KITTITAS COUNTY

MEMORANDUM

TO: All Staff
FROM: Public Works Plan Review Team
DATE: October 17, 2024
SUBJECT: BL-24-00020 Owens Road Storage

Critical Areas Map

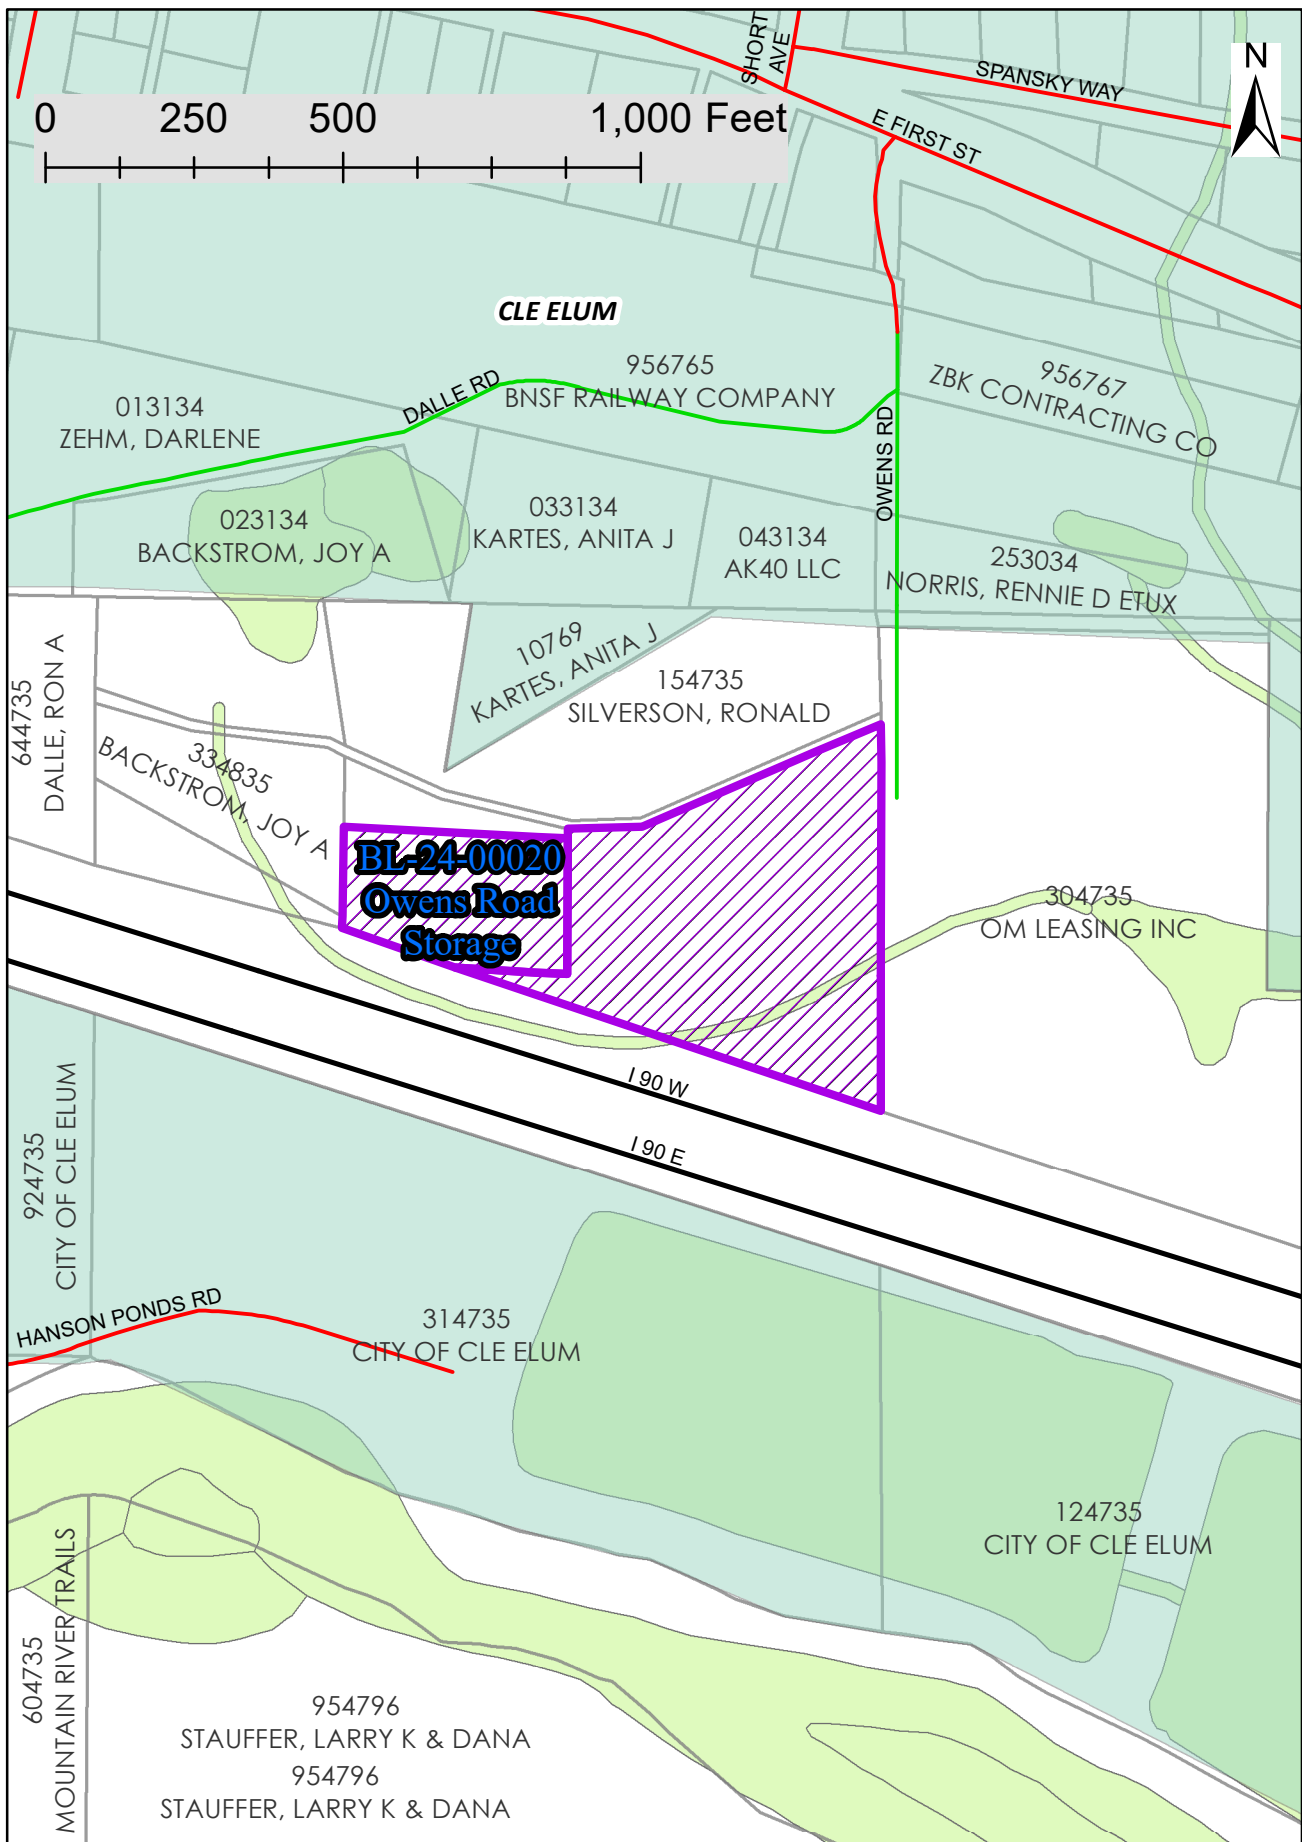
SURVEY	There are no survey comments for preliminary review. Additionally, this appears to be suitable for final submittal. (JT)
TRANSPORTATION CONCURRENCY	No comments. (JS)
FLOOD	Parcels 344835 and 364835 are mapped within the FEMA identified special flood hazard area (100-year floodplain) zone A. Any future development will require a floodplain development permit. All construction, including structures that are exempt from a building permit, must follow the guidelines within KCC 14.08. Structures may be subject to mandatory flood insurance purchase requirements. (SC)
WATER MITIGATION/ METERING	No comments. (SC)
